ID	Criterion	Description	0 (FAIL)	1 (PASS)	Rating	Appraiser Comments
ATEPAF_101	TRANSPORT ASSESSMENT: Quantitative analysis	Transport Assessments should forecast the multi-modal movements generated by a development, quantifying the additional trip generation and the distribution and assignment	No Transport Assessment submitted; or the submitted Transport Assessment has failed to provide a suitable analysis upon which to consider movement to and from the site by active modes	Transport Assessment provides a quantitative analysis of the multi-modal trip generation of the development, considering the routing of those trips to inform further considerations about the impacts and quality of existing routes within and outside of the development	1	Original TA includes multi modal trip generation.
ATEPAF_102	TRANSPORT ASSESSMENT: Qualitative analysis	Transport Assessments must provide a qualitative analysis of the current infrastructure of the surrounding area, taking into account how additional movements across all modes of transport will impact upon the capacity of public transport, walking wheeling & cycling networks.	The submitted Transport Assessment has failed to provide a sufficient e

HIMLEY VILLAGE, BICESTER - PHASE 2A - BOUNDARY TREATMENTS PLAN

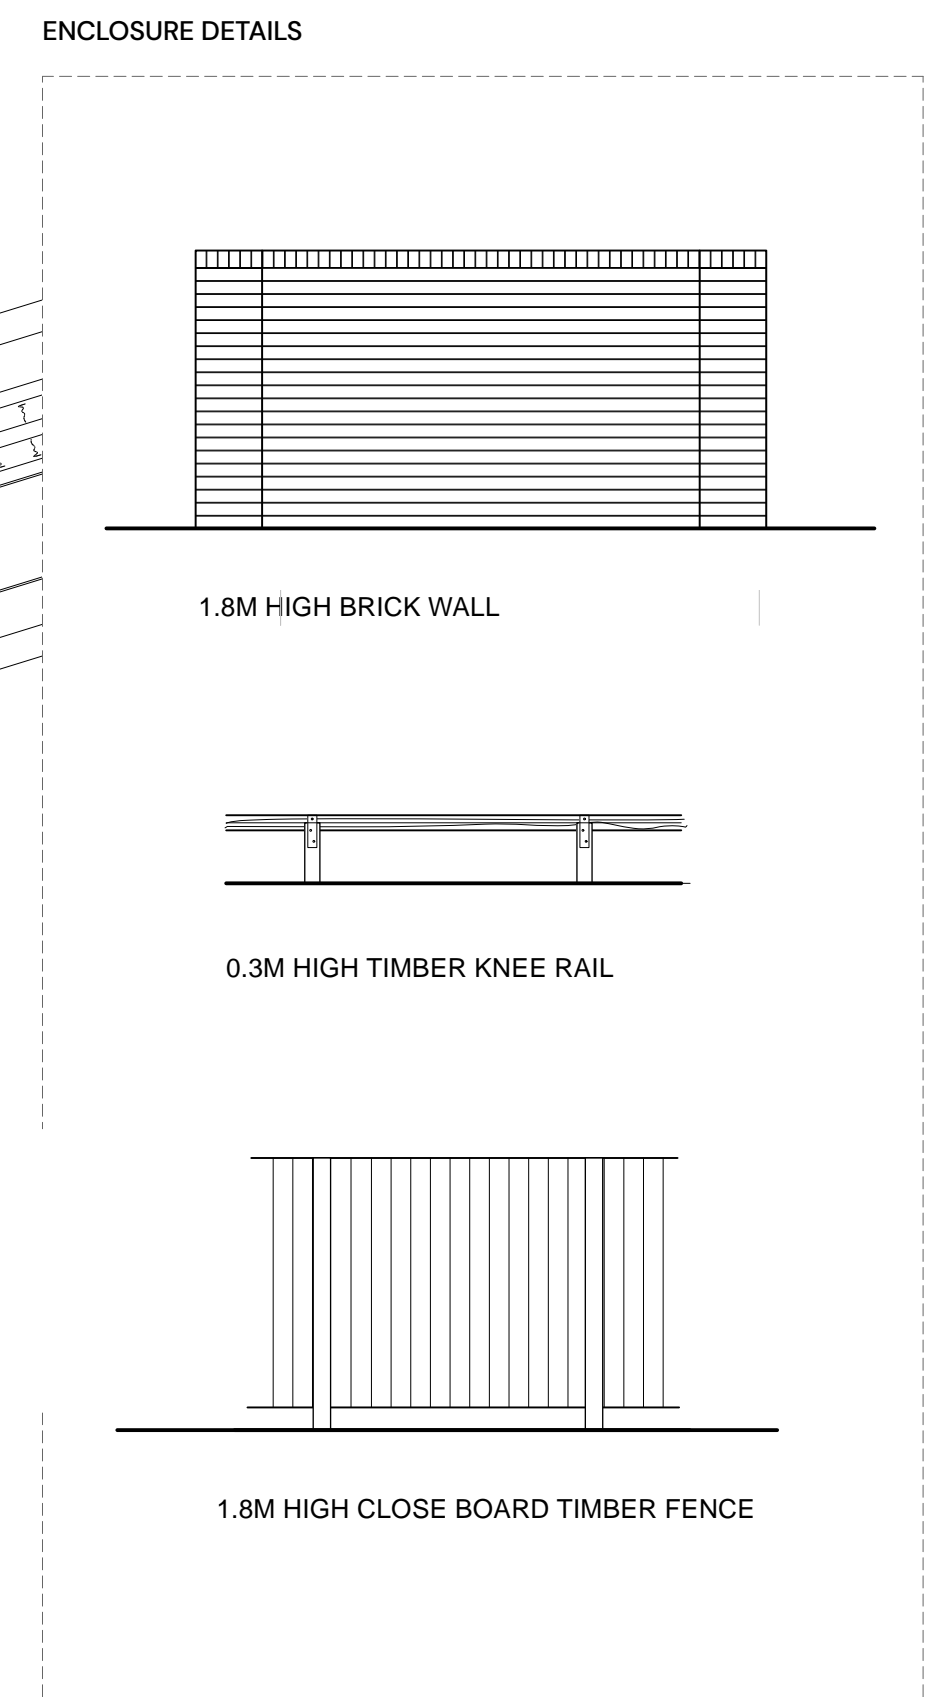
ATEPAF_117	TRANSPORT ASSESSMENT: Proposed Infrastructure	Transport Assessments must provide detail (and justification) of proposed improvements to infrastructure and any other supporting strategies which seek to enable an increase in walking and cycling rates.	The submitted Transport Assessments have not proposed improvements to infrastructure and/or not explained how the proposed development will enable an increase in walking and cycling rates.	The Transport Assessment clearly proposes improvements to infrastructure and details how they will enable an increase in walking and cycling rates.	More info needed	Good networks proposed internally, poor off site.
ATEPAF_118	Site permeability	Within the site, routes for walking and cycling should be shorter and more direct than the equivalent by car. This could be achieved, for example, through filtered permeability and the provision of car-free routes.	Journeys within the site by walking, wheeling and cycling are equal to or longer than by car	Journeys within the site by walking, wheeling and cycling are demonstrably shorter than those used by motor vehicles (excluding emergency accesses)	More info needed	Permeability is reliant on 'potential' links coming forward. Current proposals do not achieve good permeability.

ATEPAF_119	Walking and cycling access	All opportunities for safe, step-free, fully-accessible walking and cycling site access points have been maximised AND are greater in number than the number of access points for motor vehicles (except where additional accesses would provide no benefit to people walking and cycling). A motor vehicle access point with safe provision for both walking and cycling counts as a walking and cycling access point	There are fewer or the same number of accessible walking and cycling access points as access points for motor vehicles and/or not all opportunities have been taken to provide high quality and convenient access points for walking and cycling.	There are more accessible walking and cycling access points than motor vehicle access points and/or all reasonable opportunities have been taken to provide a greater number of high quality and convenient access points for walking and cycling.	More info needed	Pg 108 and 109 of the design code. The same accesses for cars and pedestrians and currently only potential future links

ATEPAF_120	Future-proofing and safeguarding	The proposals should not prejudice existing and future development and connectivity to and from adjoining sites. Where such potential may exist, development should progress within a comprehensive masterplan framework or enable a co-ordinated approach to be adopted towards the development of adjoining sites in the future	Development makes no attempt to enable, provide or safeguard walking and cycling connections to adjoining sites up to the site boundary where adjoining sites are either anticipated, planned, proposed or allocated in the local plan	Development enables and proposes the adoption of walking and cycling routes up to the site boundary to provide direct connections to existing or future development where sites are either anticipated, planned, proposed or allocated through the local plan.	More info needed	Many potential future links. These must be conditioned

Horizontal Illuminance (lux)

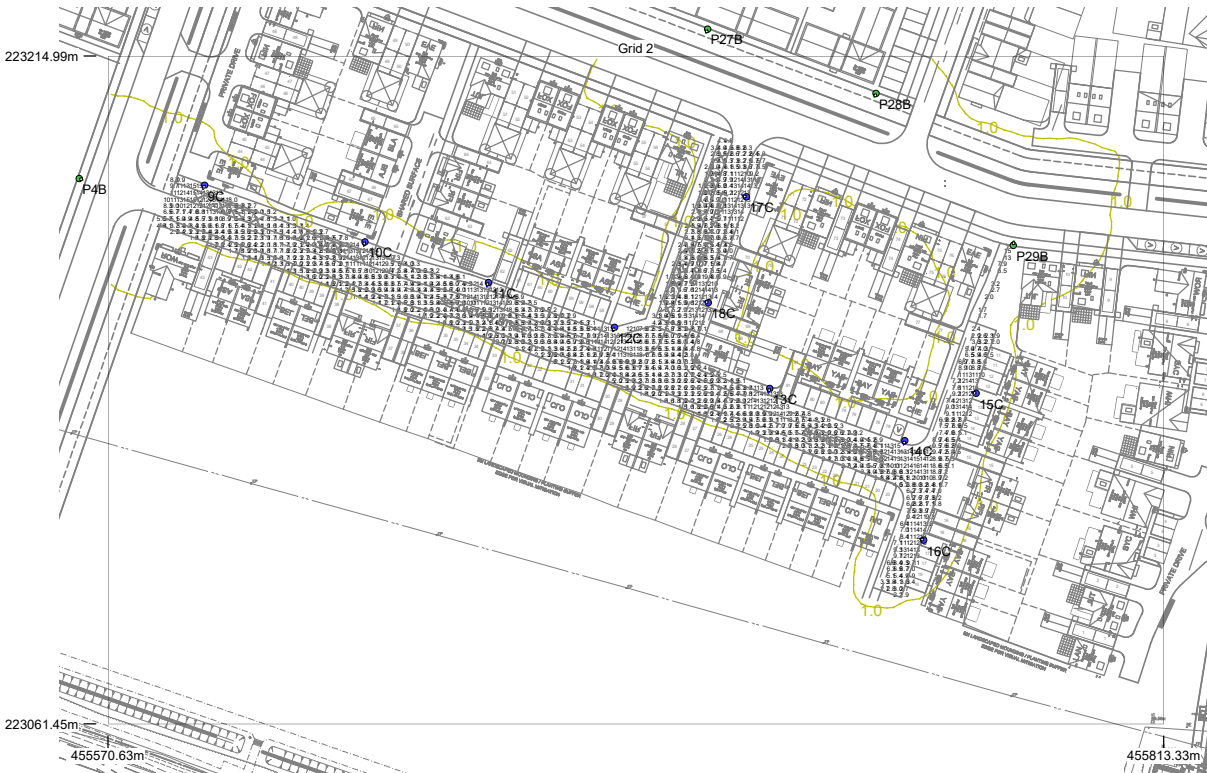
ATEPAF_112	Physical barriers for cycle users (on and off-site)	All new or improved cycle routes (within the site or outside it) must be fully accessible	The presence of steps or barriers on-site or within a reasonable distance off-site that would reduce the ease of access for a Cycle Design Vehicle (as per LTN 1/20) or the presence of situations that would require users to dismount.	No steps or barriers within the site which would reduce ease of access for Cycle Design Vehicle (as per LTN 1/20). No requirement for users to dismount at any point.	More info needed	Some segregated routes internal which are welcomed. Off site is poor.
ATEPAF_113	Lighting (on and off site)	Streets, footways and cycle routes are adequately lit at night to provide safety and security for all users	Not all routes within the boundary of the site or externally where appropriate to the users of the site are lit	All routes within the boundary of the site and off-site where required by users of the site are lit in accordance with LTN 1/20 paragraphs 8.7 and 15.3 (Urban lighting) & paragraph 8.7 (traffic free routes)	1	Lighting plan submitted and this is welcome.
